## Fire Marshal Division

**Re: Campbell University Tent  
180 Wade Stewart Circle  
Buies Creek, NC 27506**

**Application Number FMFW1809-004**

Harnett GIS

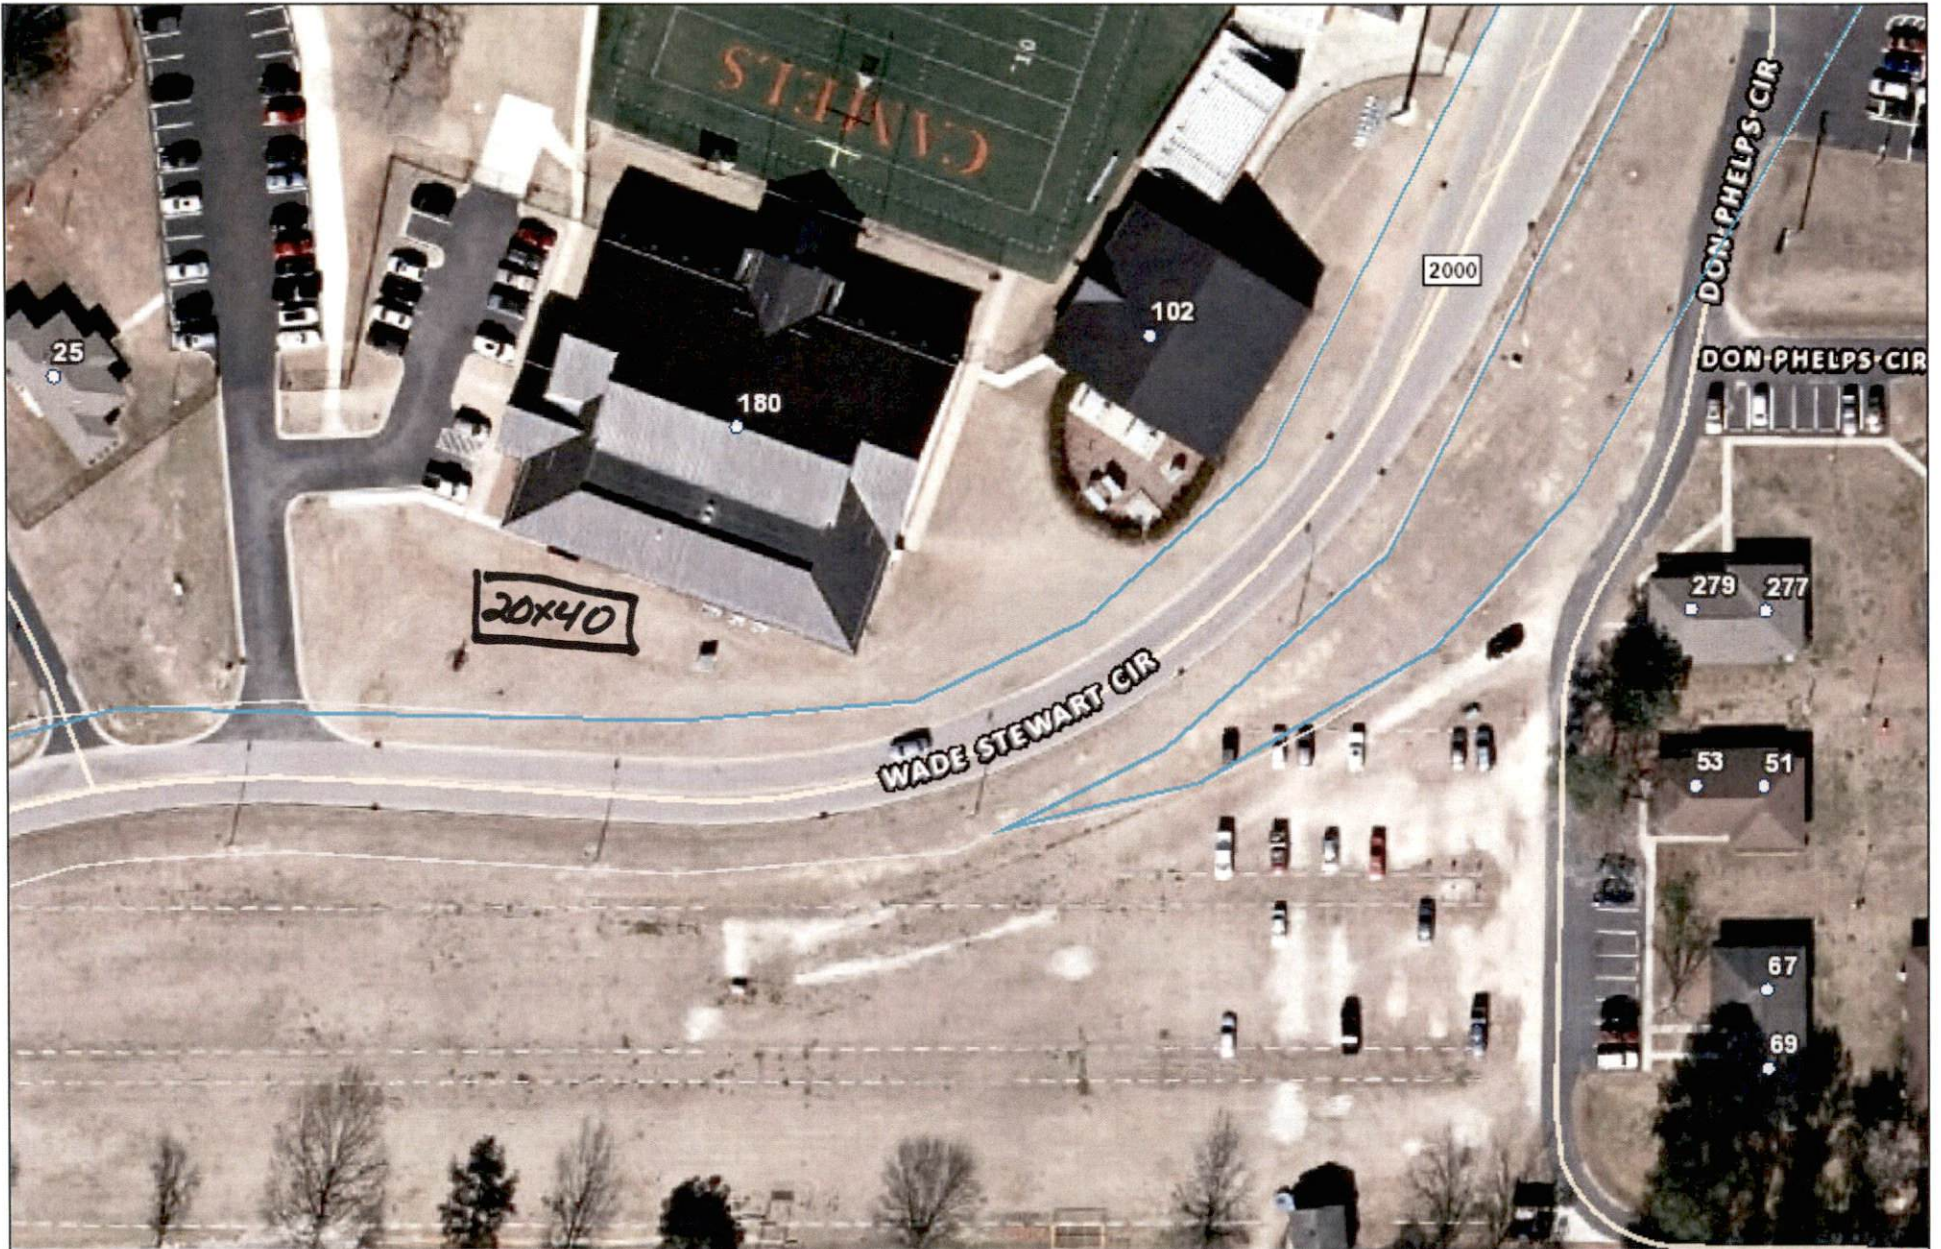
- **2404.12 Fire Extinguishers.**
  - 2A-10B: C fire extinguisher shall be placed at tents/canopies with a travel distance not to exceed 100' from any fire extinguisher.

- **2403.12.5.1 Arrangement of aisles.**
  - The arrangement of aisles shall be subject to the approval of the fire code official and shall be maintained clear at all times during occupancy.

- **2403.12.6 Exit Signs**

- Exits shall be clearly marked. Exit signs shall be installed at required exit doorways and where otherwise necessary to indicate clearly the direction of egress when the exit serves an occupant load of 50 or more.
- **2404.4 Certification**
  - Provide a flame propagation certificate from the tent owner/company.
- **2404.6 Smoking**
  - Smoking shall not be allowed under tents/canopies. "NO SMOKING" signs shall be conspicuously posted under the tent.
- **2404.19 Generators**
  - Generators and other internal combustion power sources shall be separated from tents and canopies by a minimum of 20 feet and shall be isolated from contact with the public by approved means.
- **2404.16.2.1 LP Gas Containers**
  - Portable LP gas containers that are less than 500 gallons shall have minimum separation of 10 feet between the container and the tent/canopy.
